**ANGEL PLACE
LEVEL 8, 123 PITT STREET
SYDNEY NSW 2000**

SSDA 8865 MOD 1- RESPONSE TO REQUEST FOR FURTHER INFORMATION

This letter has been prepared by Urbis Pty Ltd on behalf of Sydney Catholic Schools (SCS) in respect of the Section 4.55(2) application to modify the State Significant Development Application (SSD-8865) for concept approval and the staged construction of the St Anthony of Padua Catholic College at 125-165 Tenth Avenue and 140-170 Eleventh Avenue, Austral NSW 2179 (the project).

AA0102

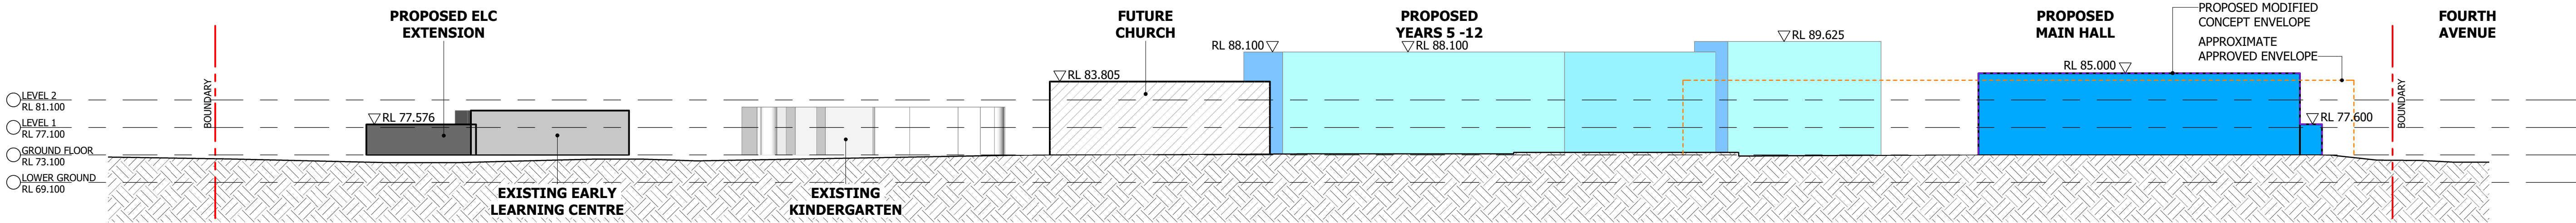
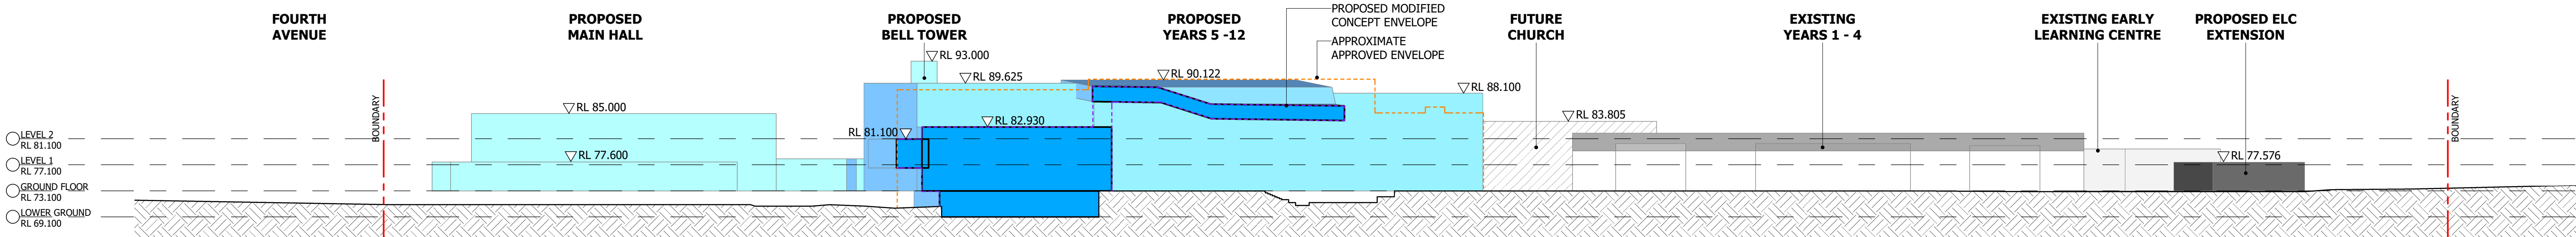
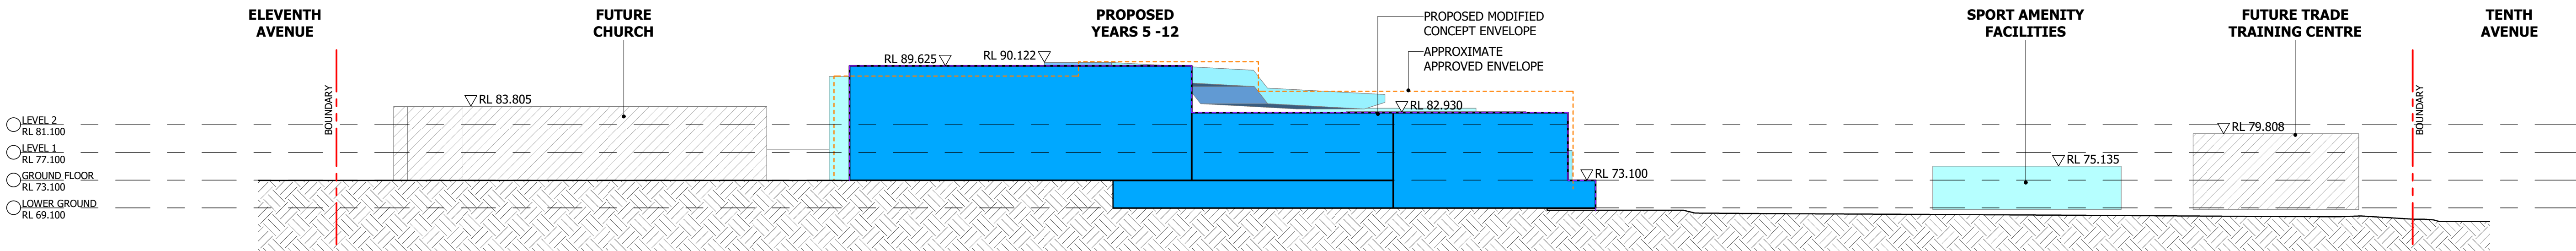
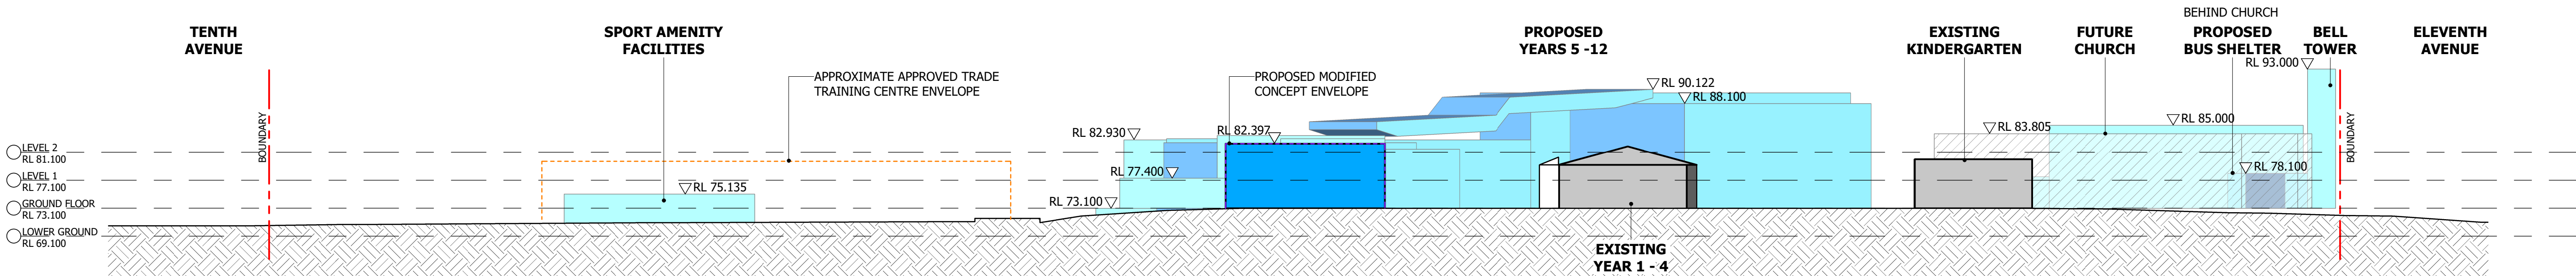
10. All architectural drawings must show RL level to top of roof and rooftop services, as consistent with the approved drawings. For example, the height of the roof of the main school building appears to extend beyond roof level RL shown on the plan.	The updated architectural plans identify the RL level to top of roof and rooftop services. Refer Attachment A.

DWP has reviewed the design refinements in relation to the Concept Approval site layout and elevational envelope. This has resulted in adjustments to the Concept Approval site layout and to the Concept Approval elevations. To illustrate this, additional plans have been included in the architectural set showing the difference between the approved site layout and elevations and the proposed modification (refer drawing AA0101 and AA0102).

The maximum RL of the main hall has also been adjusted from RL83.985M to RL 85M. These changes to the maximum approved heights have arisen as the original design as approved did not include allowances for adequate structural depth, future roof top plant or servicing requirements for the buildings.
